# PEYTON FIRE STATION

## SUBDIVISION EXEMPTION

PART OF SECTION 30, TOWNSHIP 11 SOUTH,  
RANGE 63 WEST, 6TH P.M.  
COUNTY OF EL PASO, STATE OF COLORADO

# PEYTON FIRE STATION

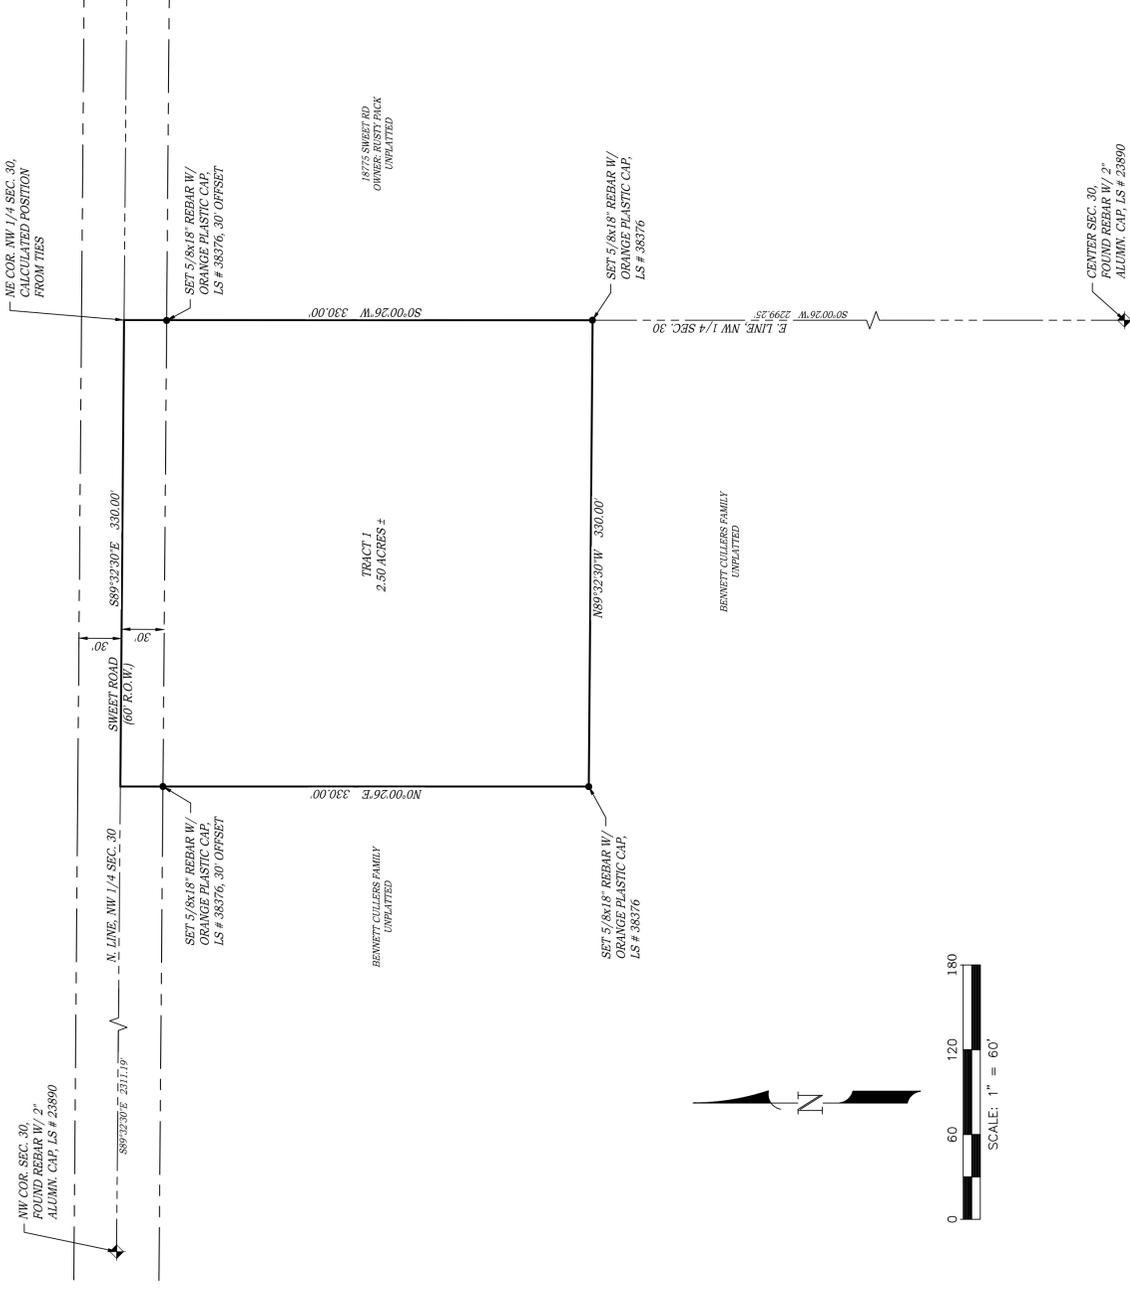
Please label dimensions.

Please label Tract 1

Once Regional Building provides the address please include that under Tract 1

Please update to 19-471

Please remove note.

Please add "PCD File No. EX234" to the bottom right hand corner.

Add under chair signature

The following note shall be placed on the plat: "Any person who knowingly removes, alters or defaces any public land survey monument or land boundary monument or accessory commits a Class Two (2) misdemeanor pursuant to C.R.S. §18-4-508."

Add the following Signature Block

Please add the following note:  
- Unless otherwise indicated, all side, front, and rear lot lines are hereby platted on either side with a 5 foot public utility and drainage easement unless otherwise indicated. All exterior subdivision boundaries are hereby platted with a 7 foot public utility and drainage easement. The sole responsibility for maintenance of these easements is hereby vested with the individual property owners.
